AL/34/20/PL & AL/35/20/L

Norton Farm House Norton Lane Aldingbourne PO20 3NH

Subdivision of existing building to create 1 NO. 1- bed dwelling & construction of 4 bay oak framed outbuilding as a garage. This application affects the character & appearance of the Norton Lane, Norton Conservation Area & affects the setting of a Listed Building.

PROJECT
ALTERATIONS TO NORTON FARMHOUSE TO FORM SEPARATE DWELLING AND ERECTION OF OAK FRAMED OUTBUILDING
DRAWING TITLE
EXISTING AND PROPOSED ELEVATIONS
SCALE
1/100 at A3
REFERENCE
11913.04

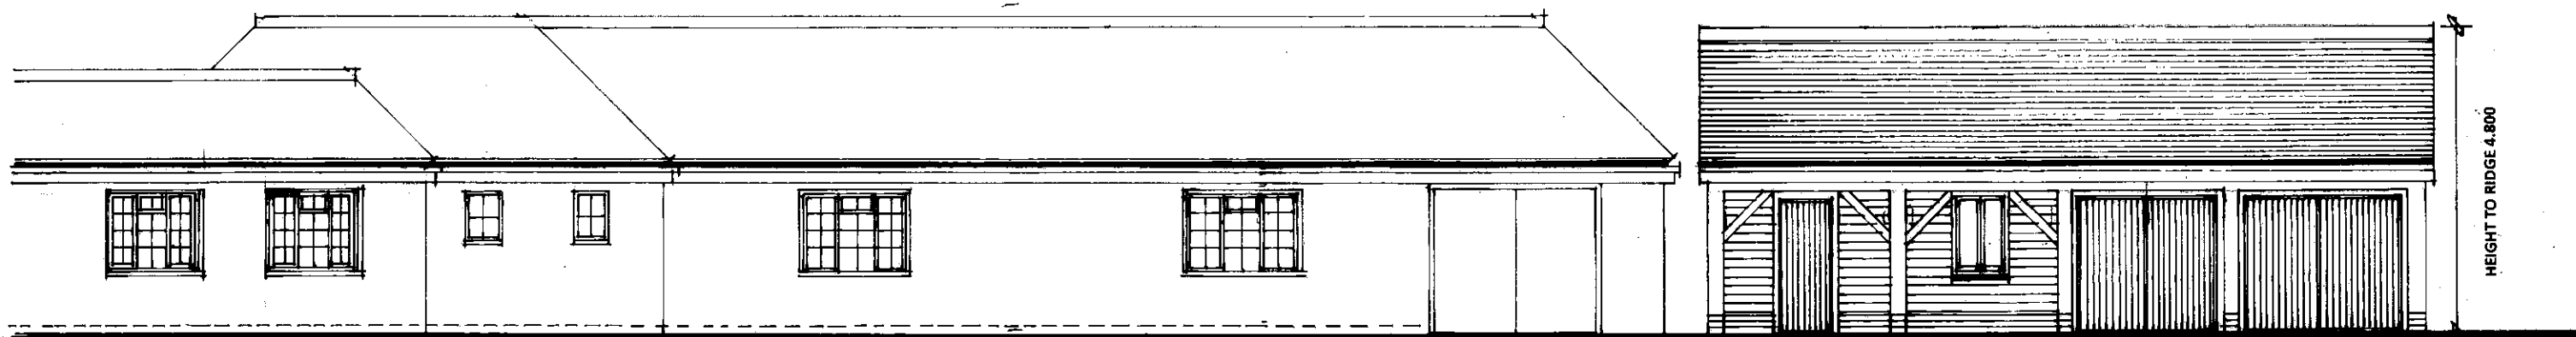
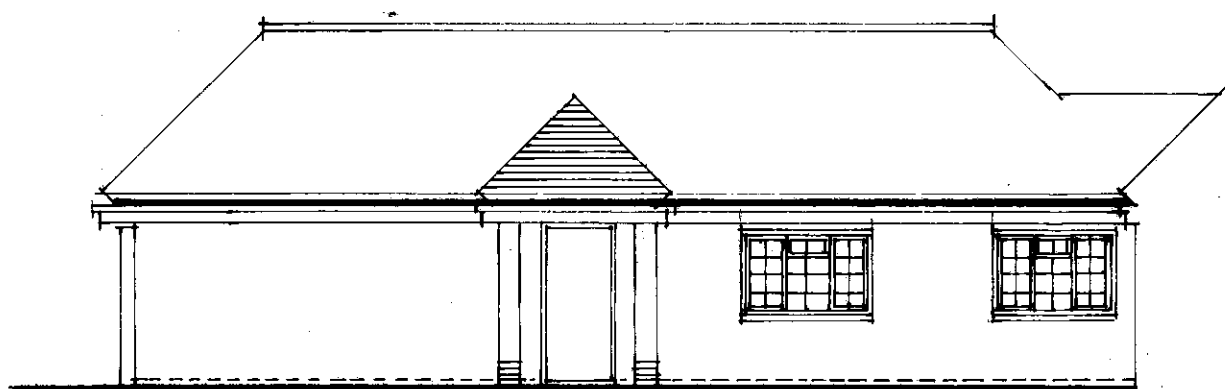
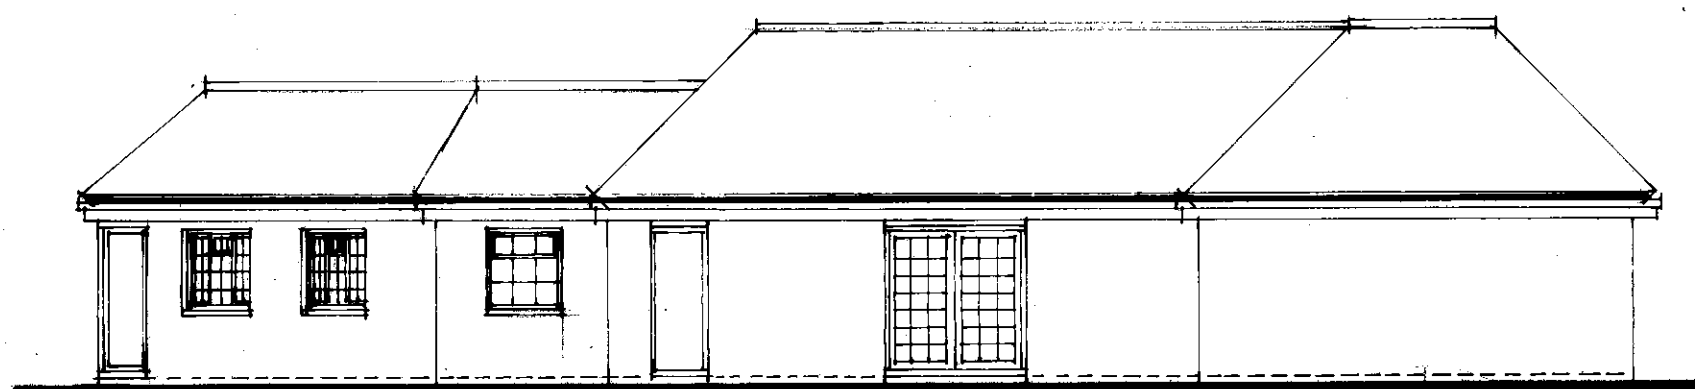
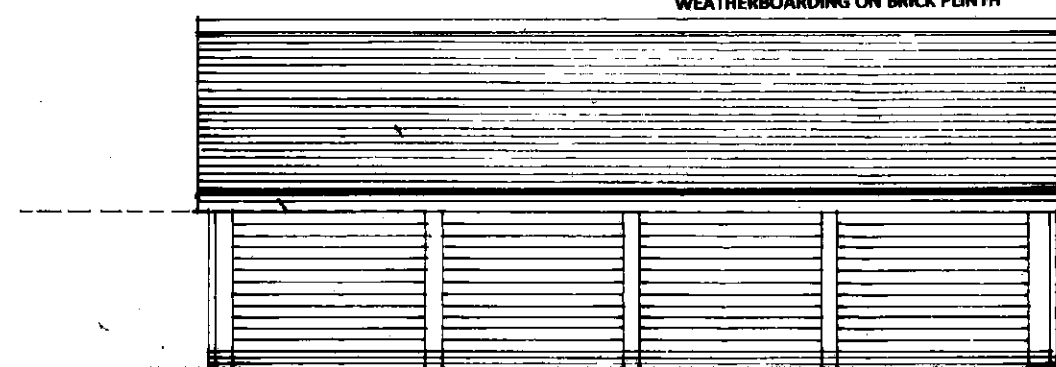
This element of the proposal affects a late C.20 extension which is located to the side of the main listed building. It is noted that the interior of the space will not significantly alter. Externally, a new entrance door and porch would be constructed to provide access from the south courtyard and a window would be replaced by a pair of French doors on the west elevation. Such alteration will not harm any historic fabric, and their success will depend upon their appearance and construction.

The separate detached structure appears to be generally acceptable. The use of hand-made tiles to match the existing adjacent building and the use of larch feather edge weatherboarding would reflect the character of the building.

Details of the proposed garden boundary, the new joinery and their treatments should be provided by way of condition if you are minded to approve the proposals.
